Consultation Response from KC, Conservation & Design

Application: 2025/91225 & 2025/91226

Address: Bradley Hall, Lower Quarry Road, Bradley, Huddersfield, HD2 1FN

Proposals: Change of use from dwellinghouse with barn to mixed- use Light Industrial for the production of wood fuel (biomass) and dwellinghouse; the construction of a detached workshop/storage building; extension and alterations to the existing building, formation of new access and other associated works. (Listed Building)

drawing: PROPOSED WORKSHOP / SHED
PLANS AND ELEVATIONS

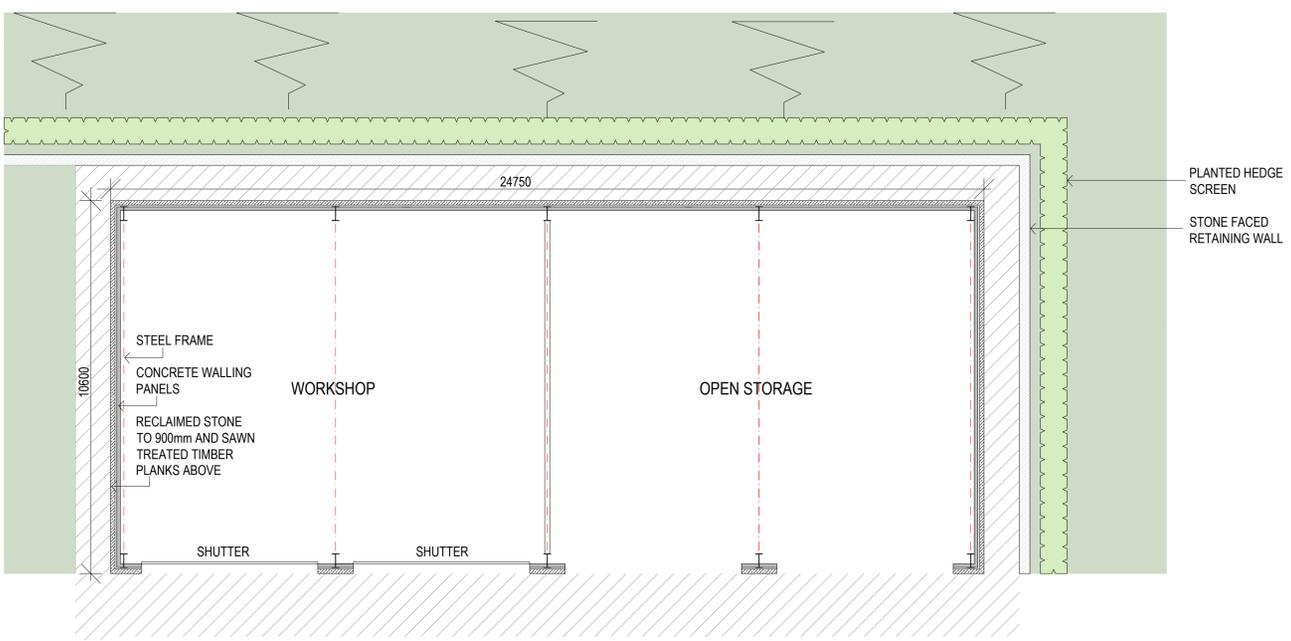
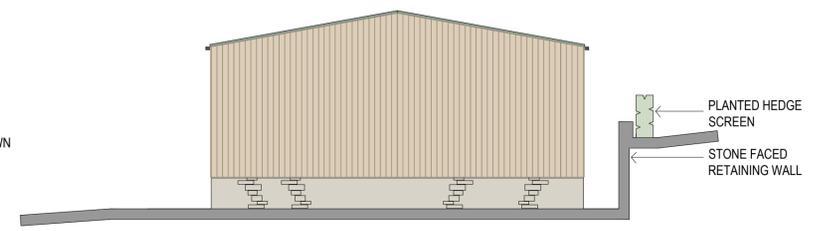
The proposed workshop sits within the wider setting of the listed building. Due to its open surroundings, it does not interrupt on any important views into or from Bradley Hall. The

simple design and use of reclaimed stone ensure that the new workshop will remain sympathetic to the character and appearance of the listed building.

drawing	RENOVATED BARN / COTTAGE PLANS AND ELEVATIONS AS PROPOSED
---------	--

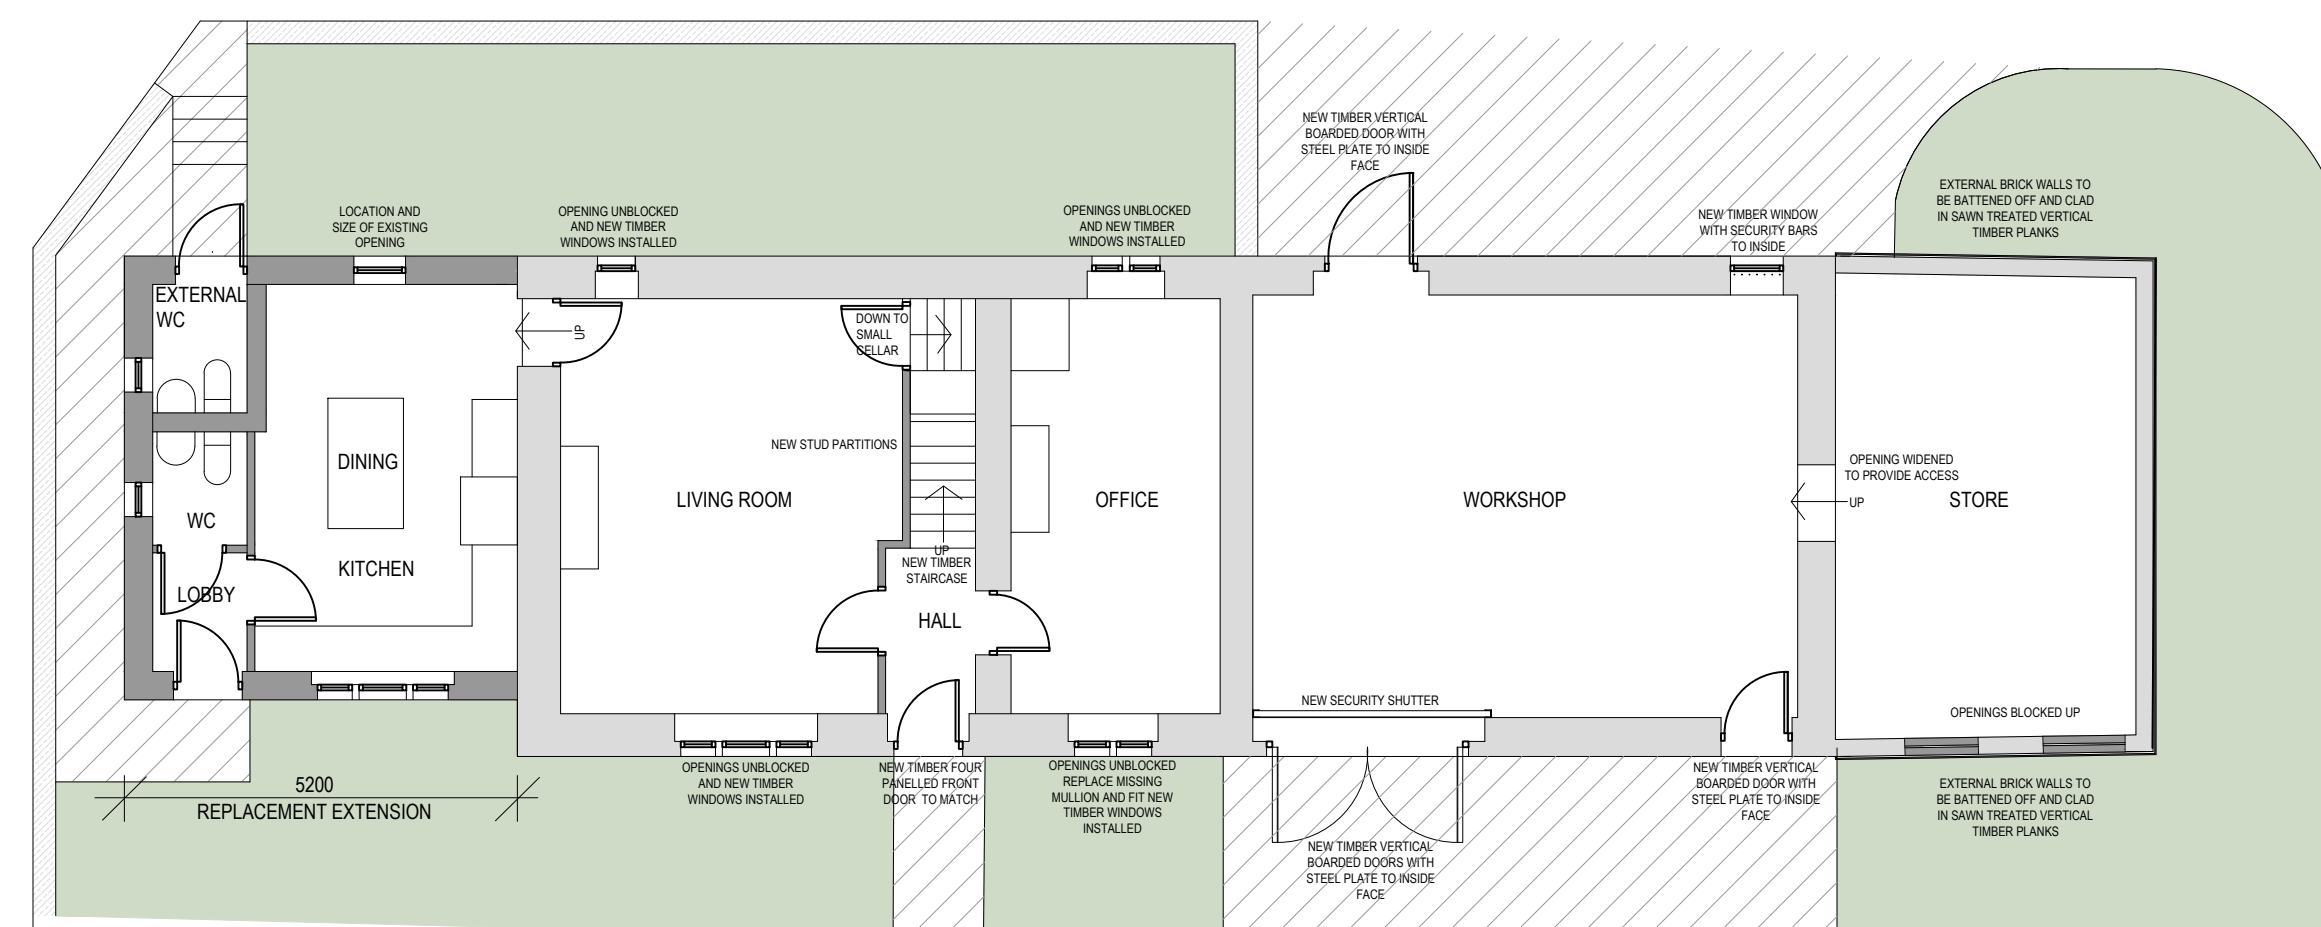
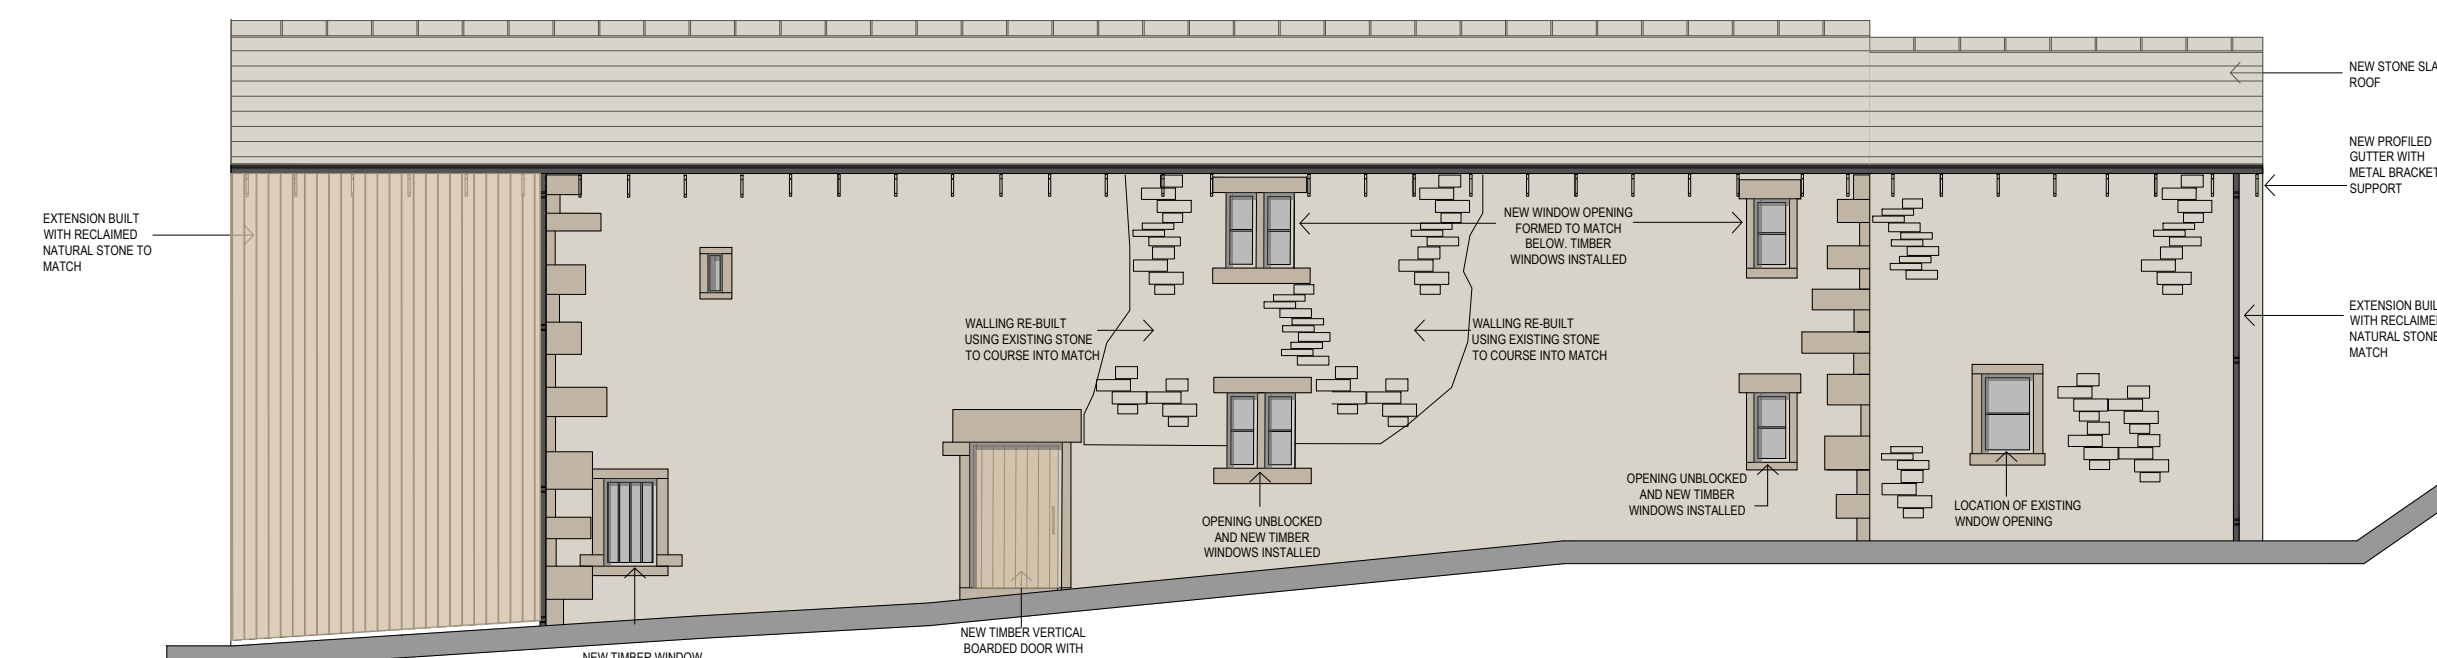
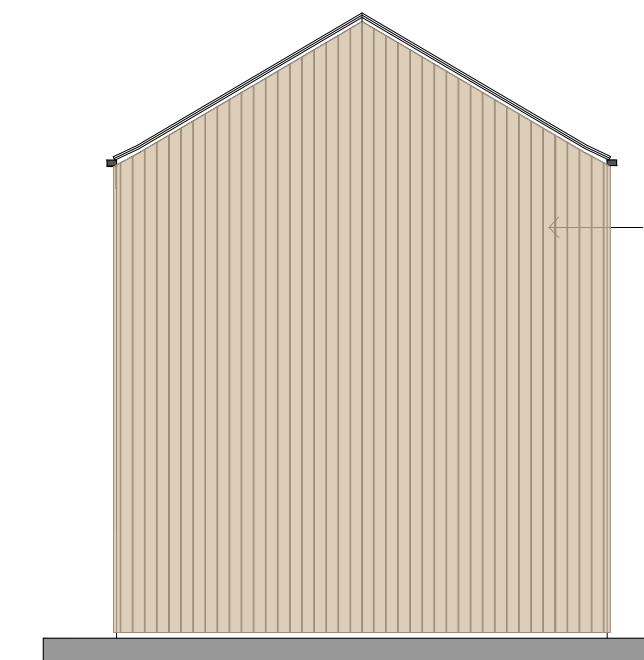
- The proposed new windows are of an appropriate design, with timber frames and the retention of existing stone mullions.
- New window openings are limited, proportional, and reflect the established character of the barn.
- Existing small glazed vents are to be retained, which is supported.
- The use of stone slate for the roof is appropriate and consistent with the building's historic appearance.

The barn currently has a small derelict extension at its gable end. The proposal replaces this with a new structure that is both lower in height and set back from the main barn, allowing it to be read clearly as a later addition. The use of reclaimed stone is appropriate, although samples should be conditioned to ensure compatibility with the existing stonework.

My only concern relates to the proposed timber panelling over the brickwork. It would be helpful to explore whether exposed brick or a rendered finish might offer a more sympathetic and durable alternative, depending on the quality and appearance of the existing brick beneath.
